November 26, 2024

**Re: Japanese Kitchen at 8201 La Morada Pl. NE
Erosion and Sediment Control Plan
Engineer's Stamp Date 11/25/2024 (G19E004I)**

Sincerely,
James D. Hughes, P.E., CPESC

TEMPORARY EROSION AND
SEDIMENT CONTROL PLAN

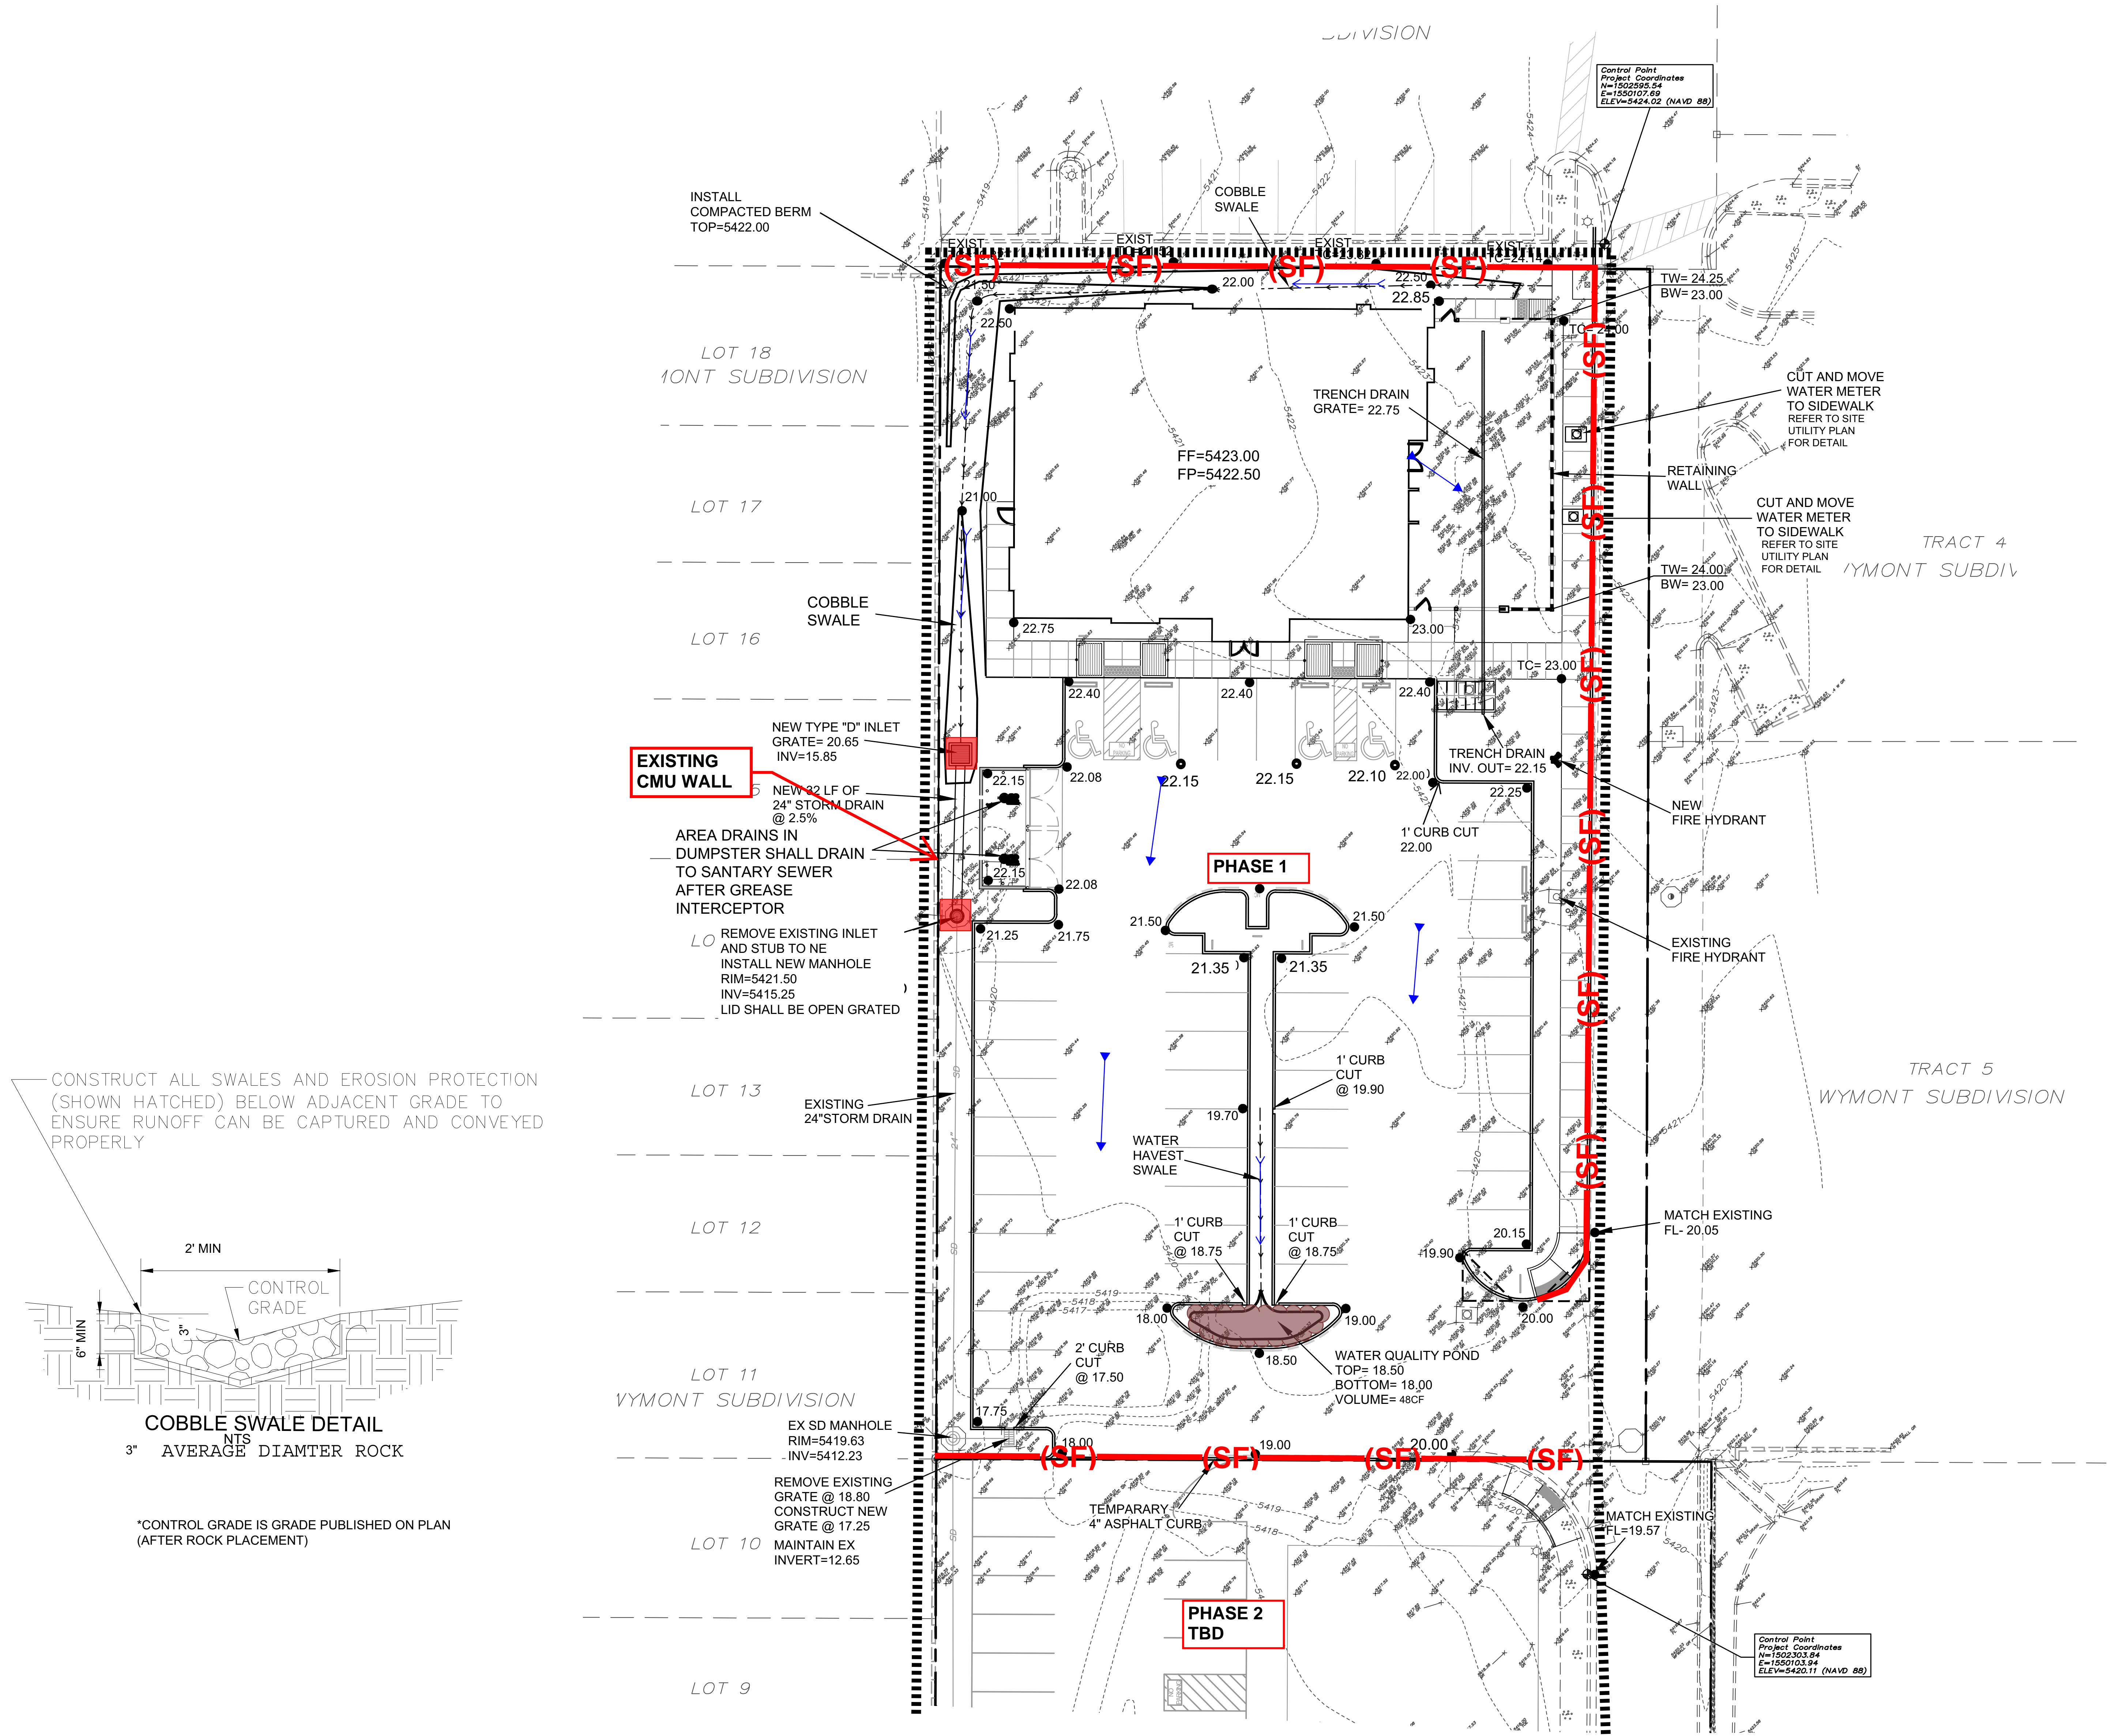
Based on the information in your submittal, received on 11/25/24, the above-referenced ESC Plan is approved to be included in the SWPPP, with the condition that it is modified to include the existing and proposed drainage conditions and a managing member of Mira Al Sol certifies the NOI before the city will issue any Building Permits.
